## **Introduction**

## **Parameters Plans**

## **Density and Design Character**

## **Summary**

6. Land Use Parameter Update

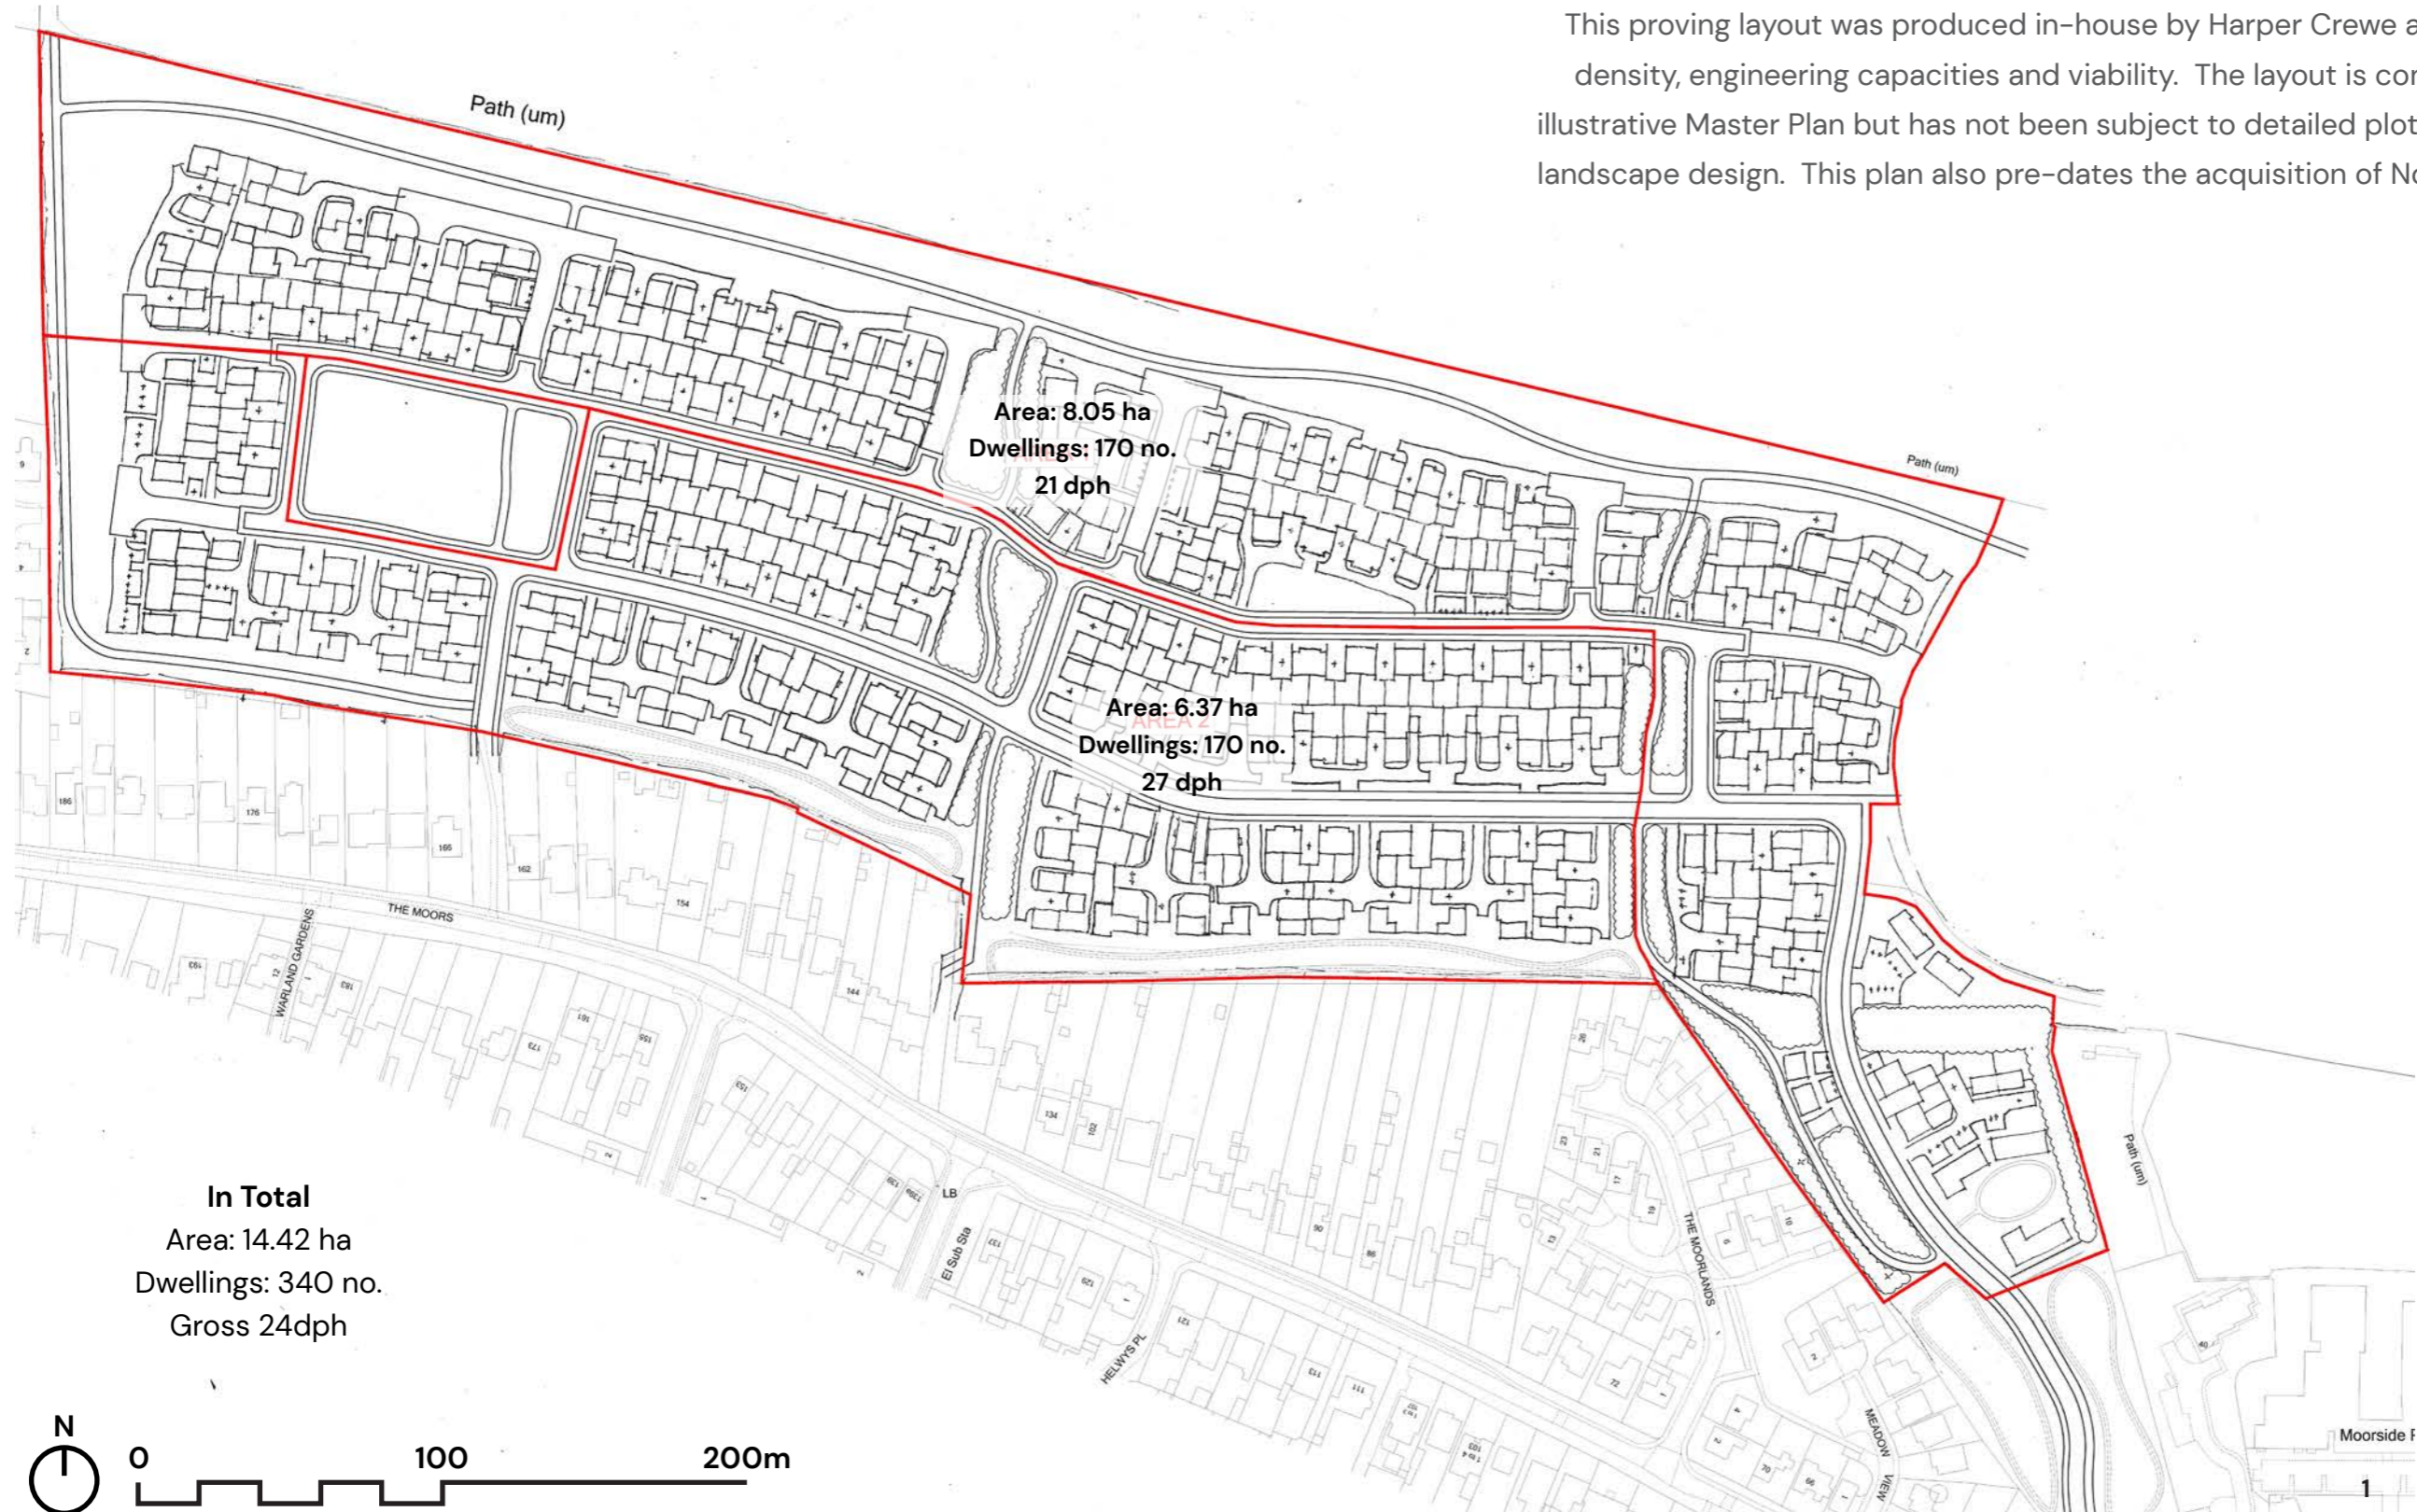
- Parameter Plan: Please remove the word 'circa' in relation to the Western Green
- Additional Information: Based upon the illustrative masterplan please provide a clear indication of the densities proposed across the site and vignettes at key locations to demonstrate the approach to density/parking/ street scene to demonstrate the scheme can be delivered in accordance with policy, guidance and best practice.
- Conditions: As set out within my previous comments of the 19<sup>th</sup> June plus a condition to cover key views.
